**Precinct Marker Signage Strategy - SSD-7317-Mod-19
Request for Additional Information**

Attachment 1

ELEVATION 01 – LOOKING WEST TOWARDS LOCOMOTIVE WORKSHOP
SCALE 1:75

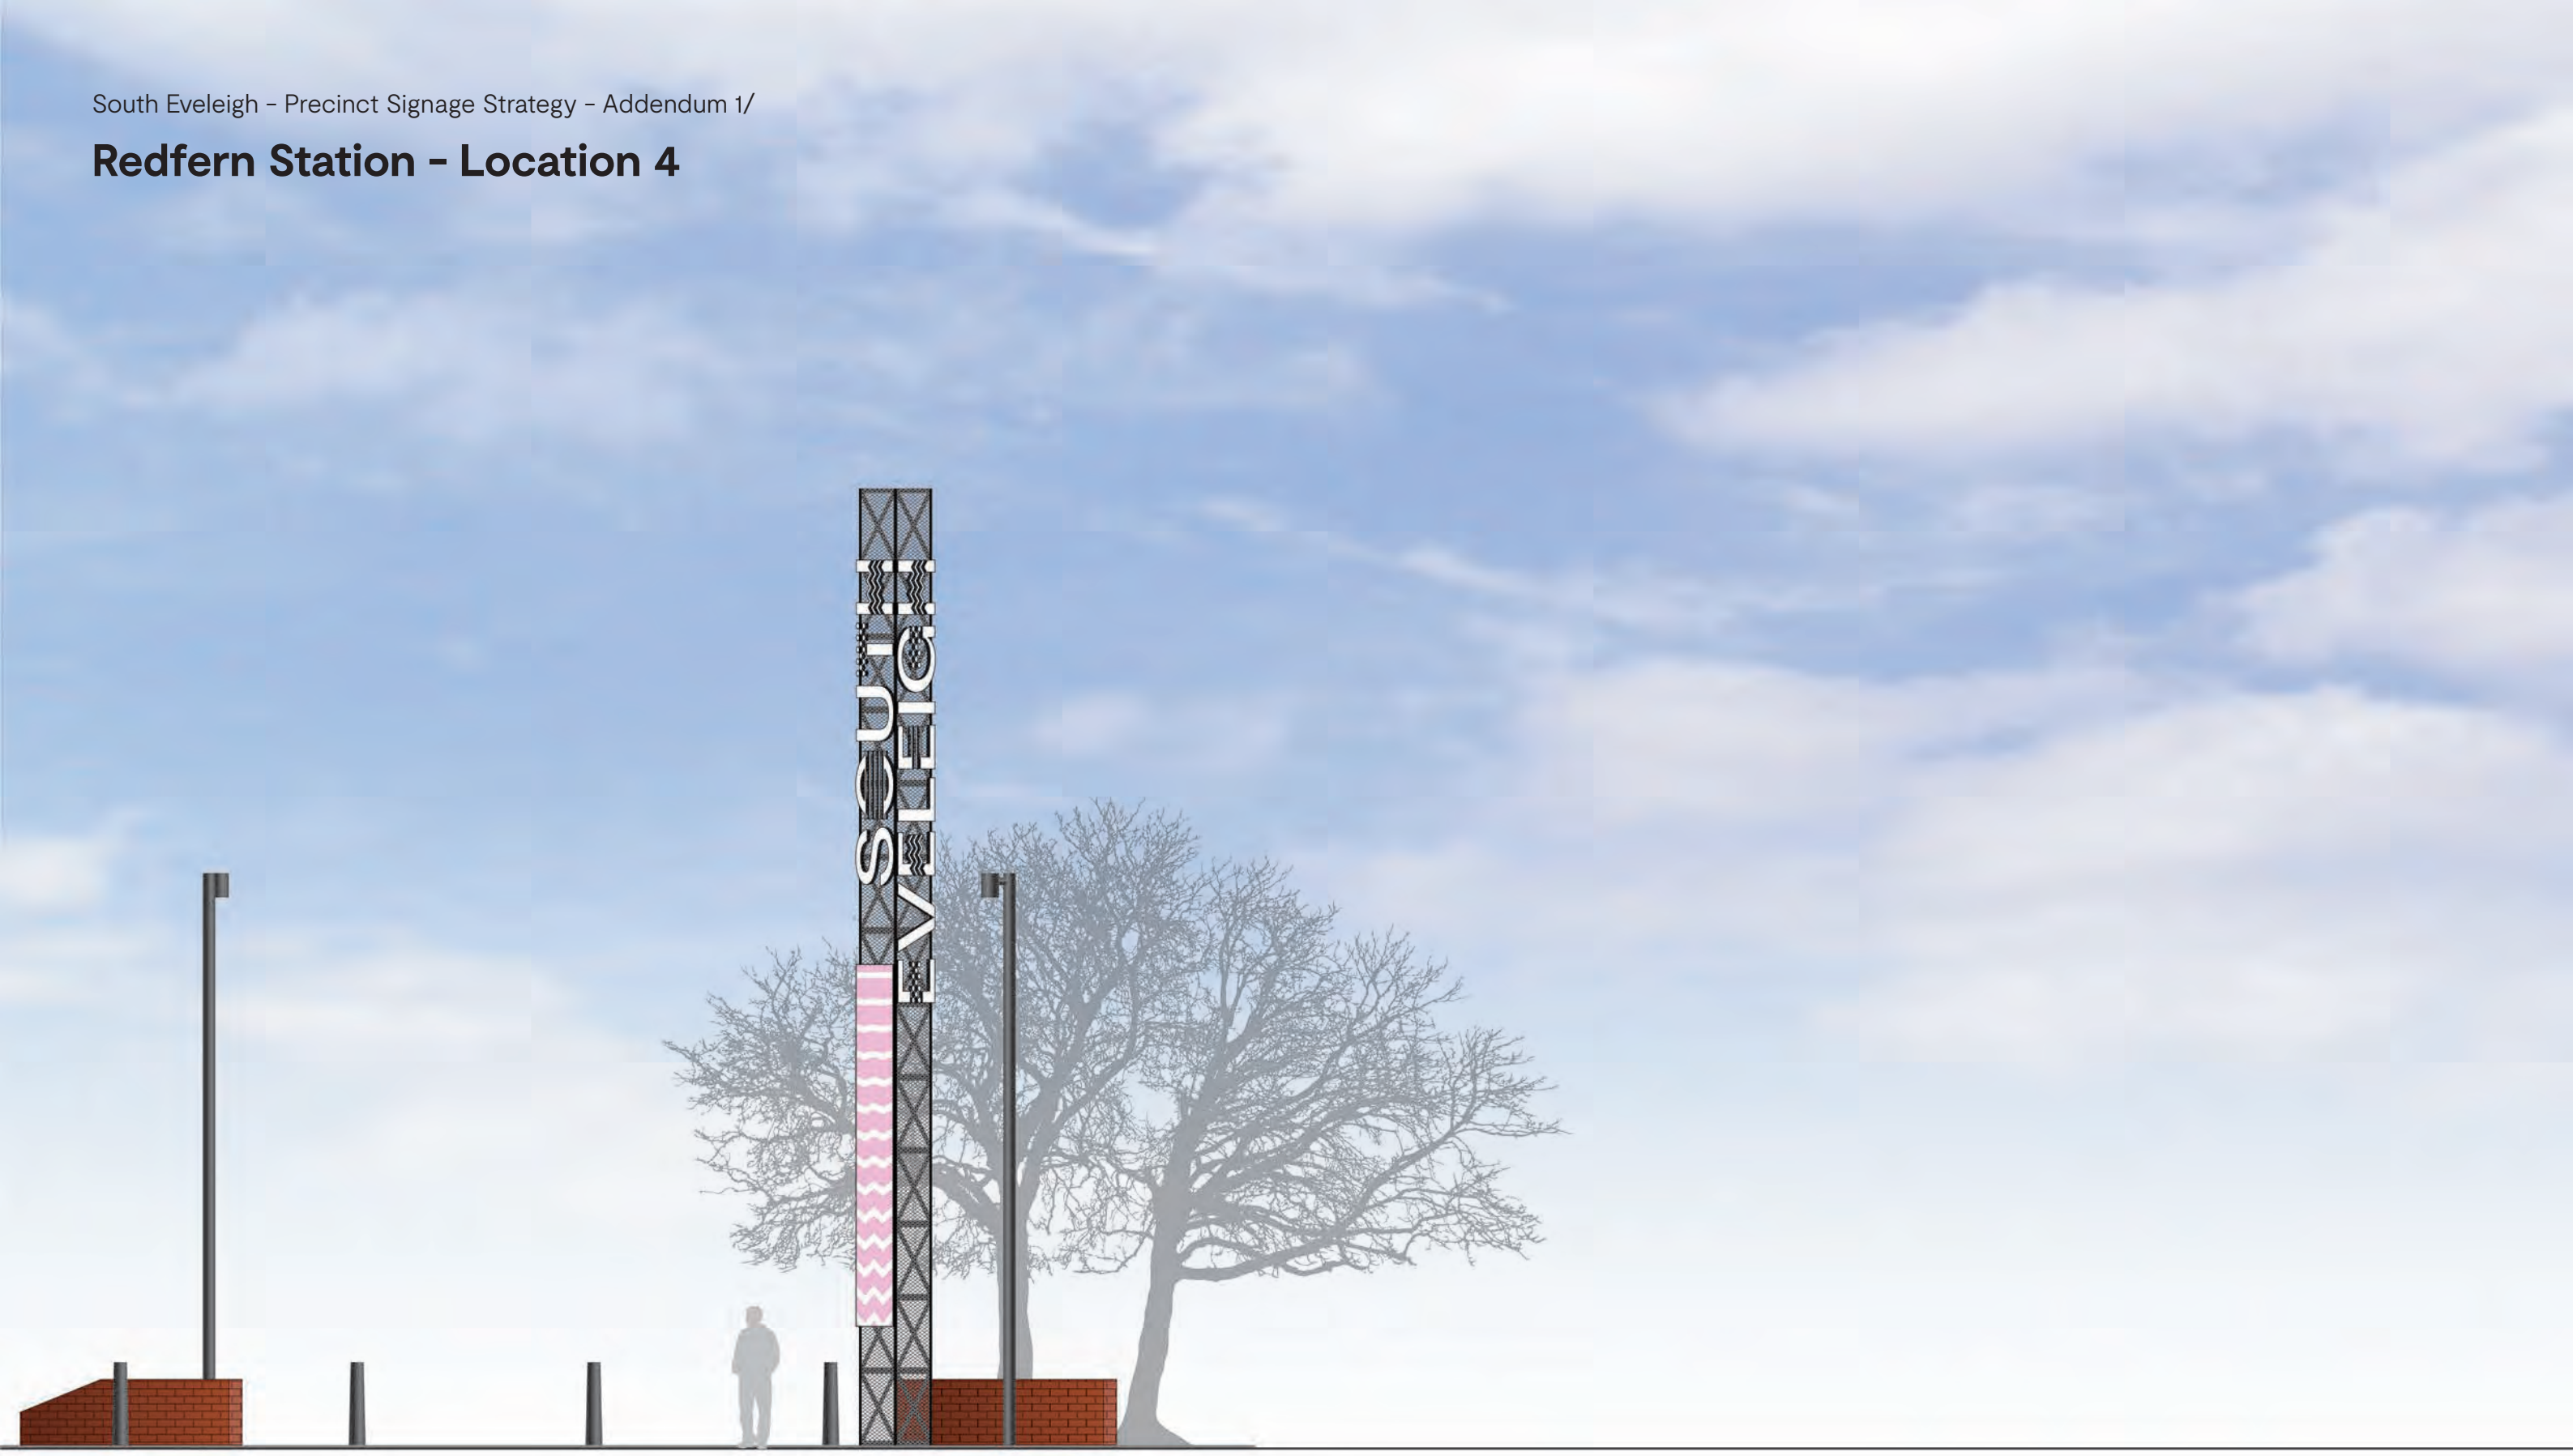
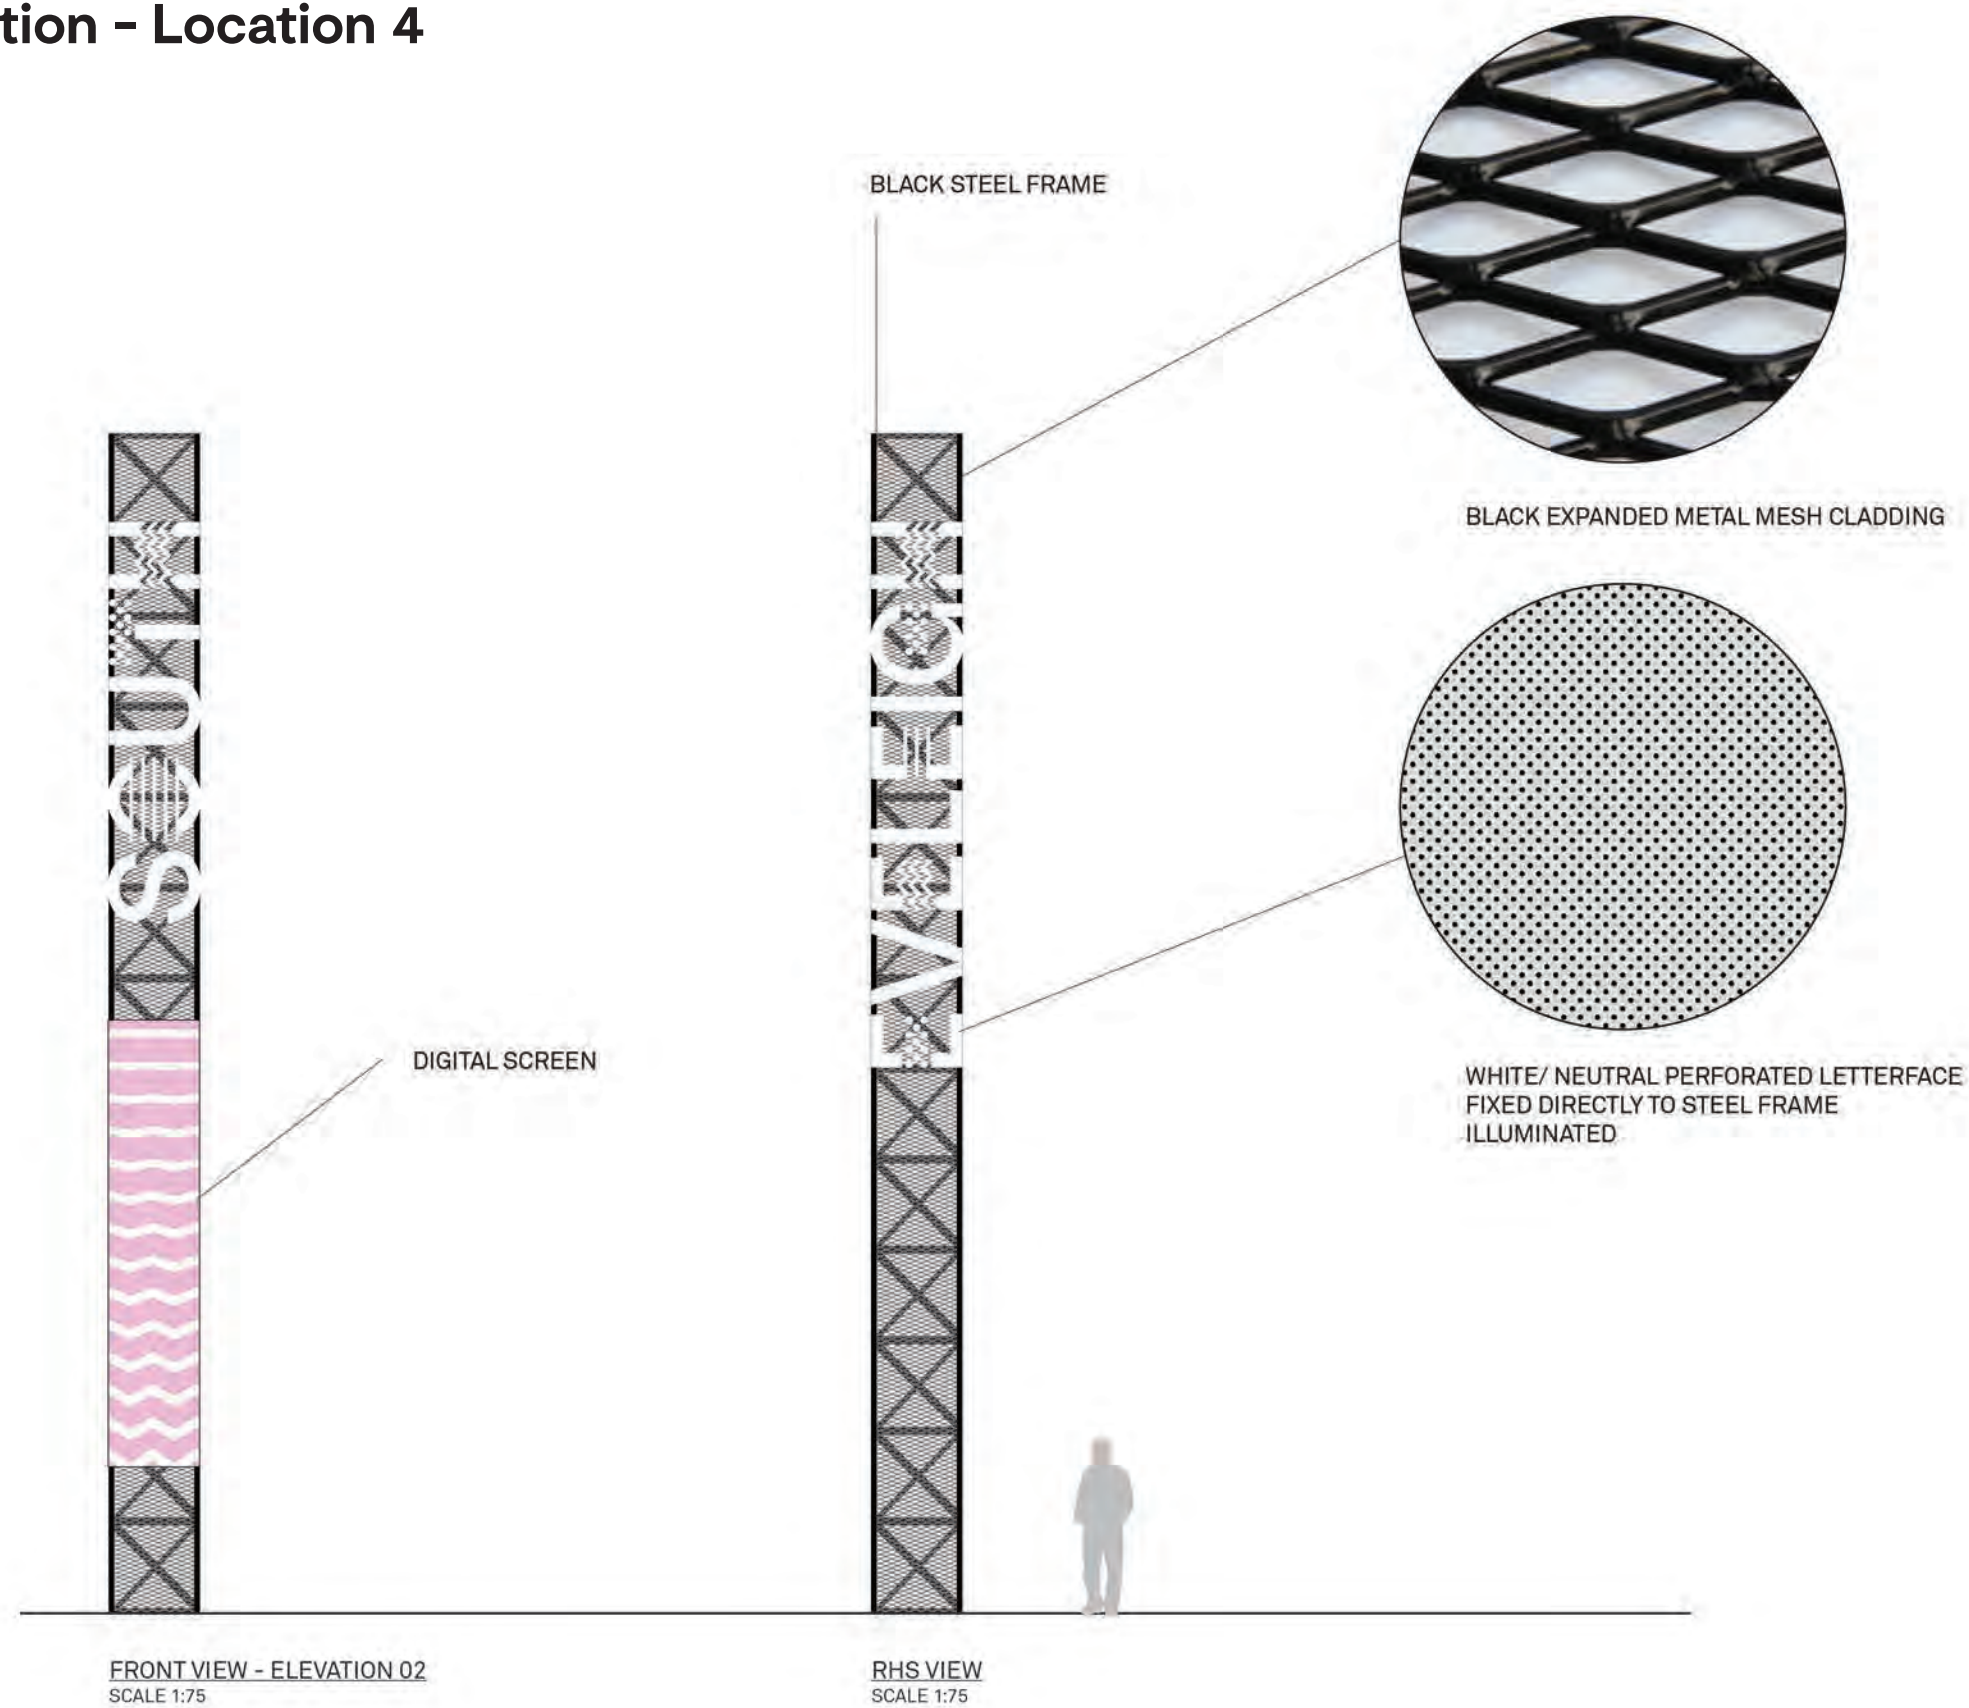
The Department acknowledges the intent of Redfern Station signage is to allow recognition of the precinct from the broader area, including Redfern Station. However, the Department questions the need for and appropriateness of a tall illuminated sign in this location noting the proximity and prominence of the signage to the Watertower residential apartment building.

Having regard to the above, and the concerns raised in public submissions, the Department requests that you give further consideration to the location, height and illumination of the sign.

- a. a day time and night time montage
- b. an elevation showing the proposed sign and the adjacent Watertower building, including the floor levels of this residential building, including identification if the western elevation windows of the Watertower are living room or bedroom windows
- c. the location of the public art to be installed in this area and provide details of the public art.

FRONT VIEW - NIGHT
SCALE 1:75

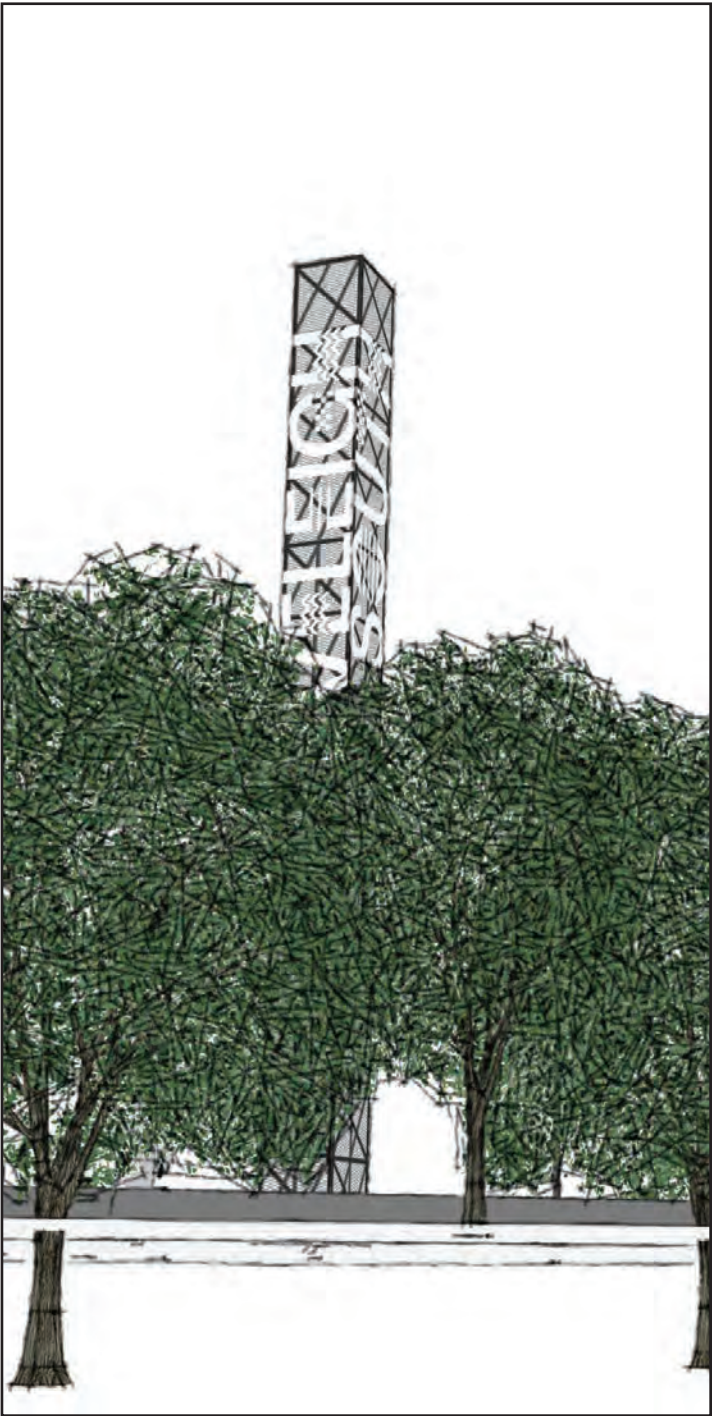
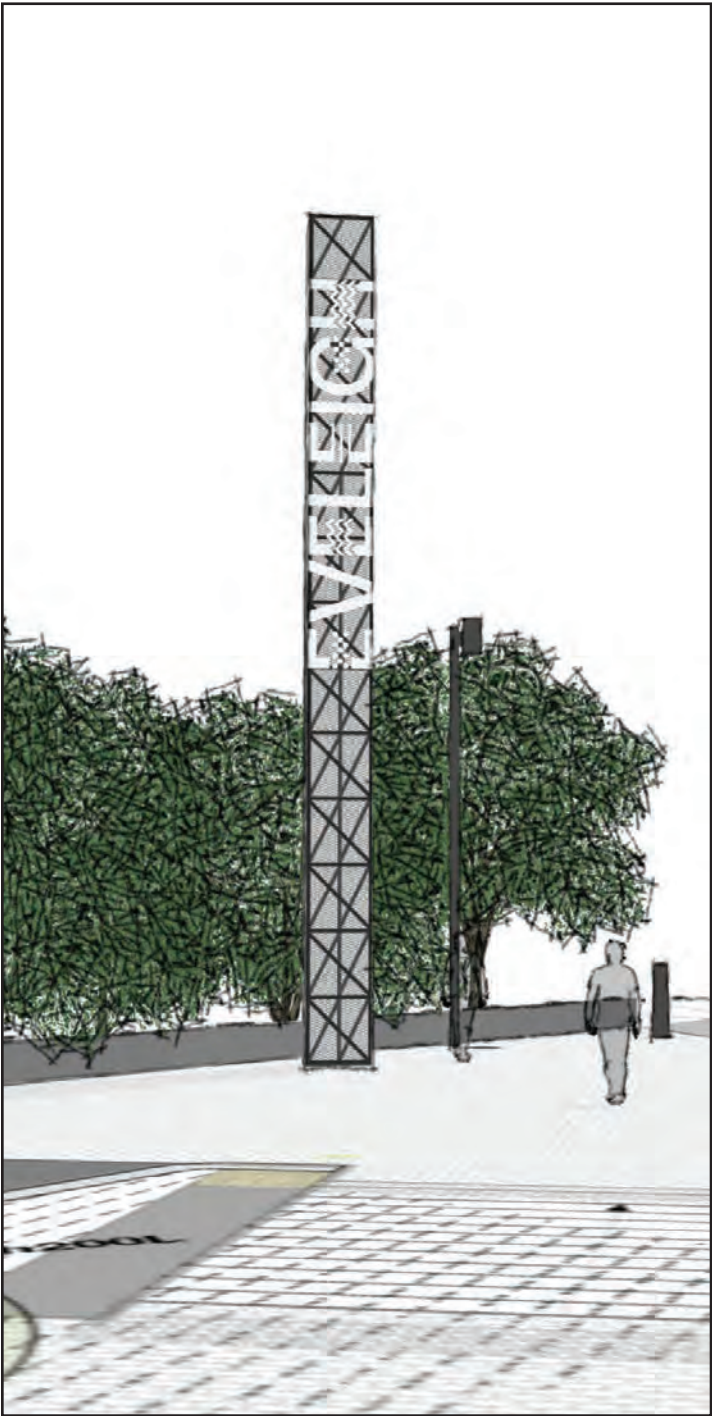
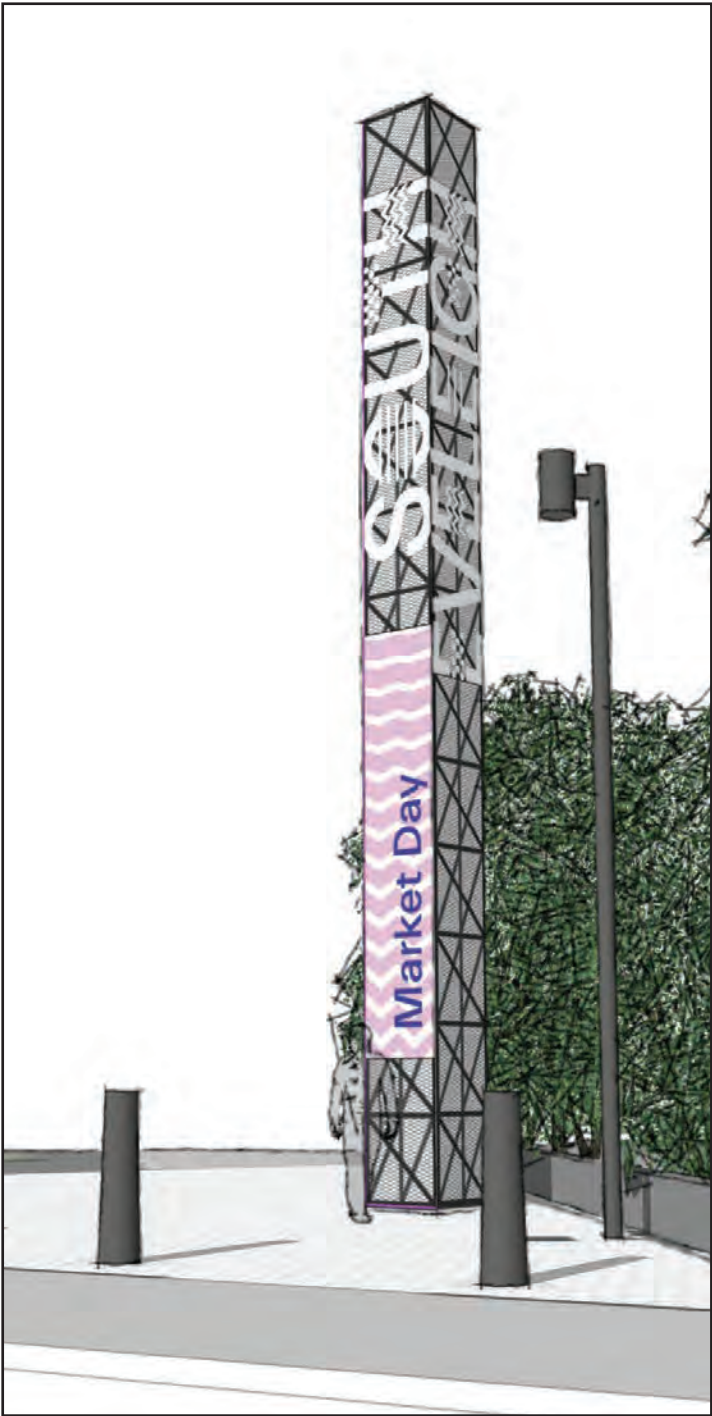
- a. The Department requests that you reconsider the extent and hours of illumination of signage at locations 2, 3 and 4 having regard to the concerns raised in submissions.

Consideration should be given to reducing the overall hours of illumination for the signs, or elements of the signs, to minimise potential impacts on nearby residences, while maintaining the intent of the signage to identify the entrance to the precinct and provide wayfinding for vehicles and/or pedestrians.
